WEST SUSSEX COUNTY COUNCIL CONSULTATION

TO:	Arun District Council FAO: Maria Tomalova
FROM:	WSCC - Highways Authority
DATE:	23 September 2019
LOCATION:	Land adjacent to Cherry Trees Lake Lane Barnham PO22 0AD
SUBJECT:	BN/75/19/PL 1 No. dwelling & associated works.
DATE OF SITE VISIT:	n/a
RECOMMENDATION:	Modification
S106 CONTRIBUTION TOTAL:	n/a

SITE PLAN  
1-200.

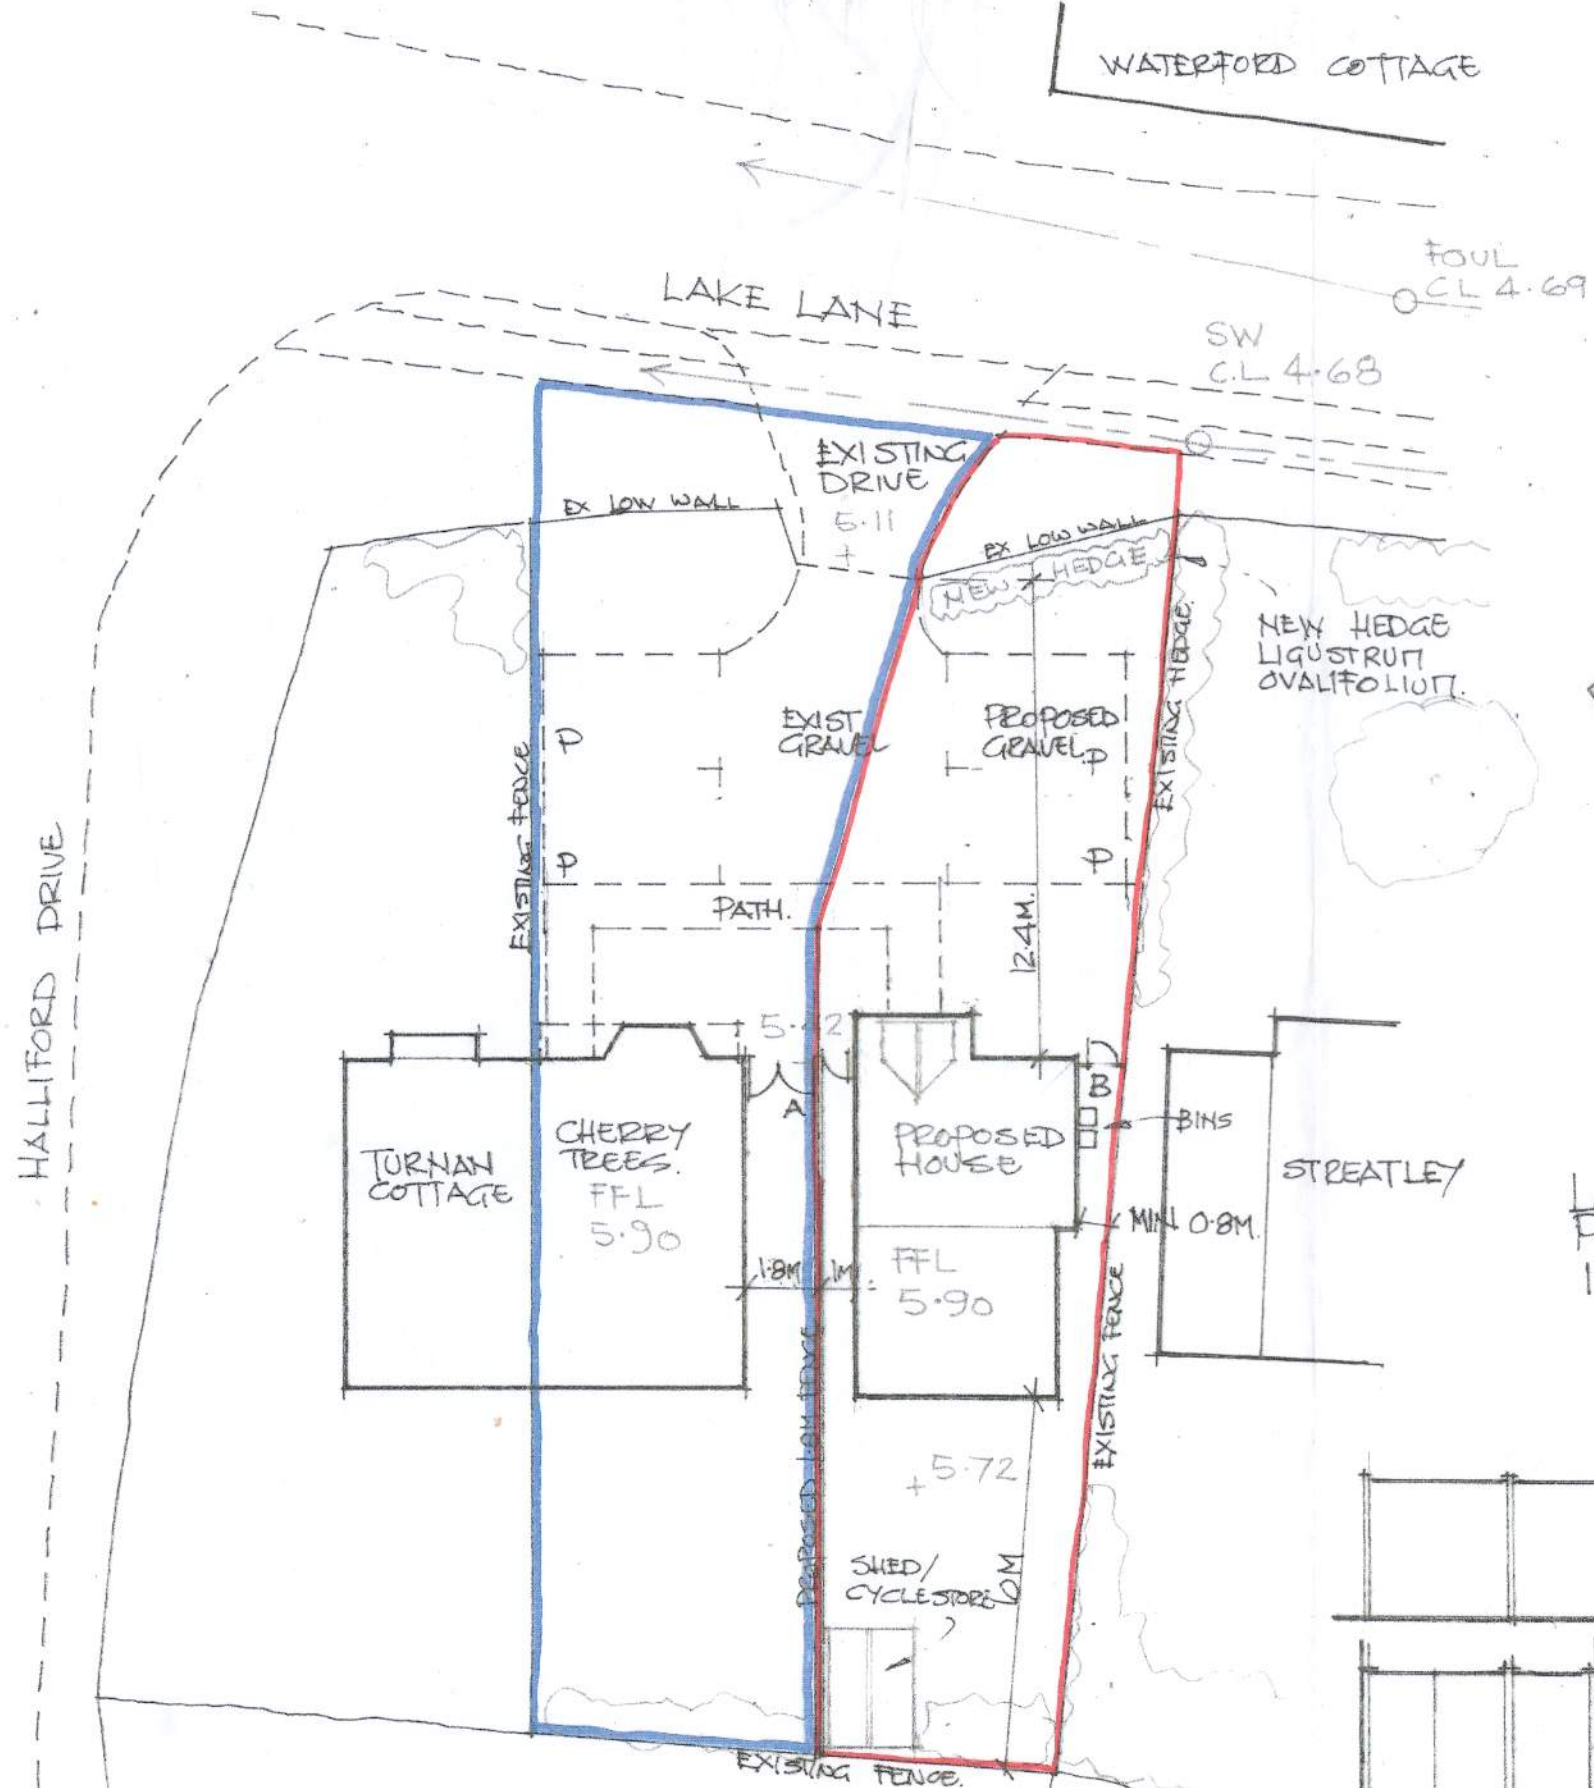
The applicant has not stated that the area to the centre of the parking zone will be used as a turn onsite; however upon inspection of the plans the LHA observed that the area is

large enough (Minimum 6 metres at 90 degrees) that it can accommodate such a manoeuvre and allow the applicant to enter the highway in a forward gear.

The applicant has proposed a nil cycle parking provision, as per the WSCC Sustainability policy we wish to see this implemented in the form of lockable covered storage.

Whilst there are no overriding highway safety or capacity concerns with the proposal before me now, the applicant would be advised to modify the proposed with cycle parking.

We would be minded that such an amendment could be secured via planning condition, with accommodating plans to be submitted to and approved by the local planning authority. However given recent changes to the National Planning Policy Framework (NPPF) ideally this matter should be fully resolved by the applicant prior to determination.
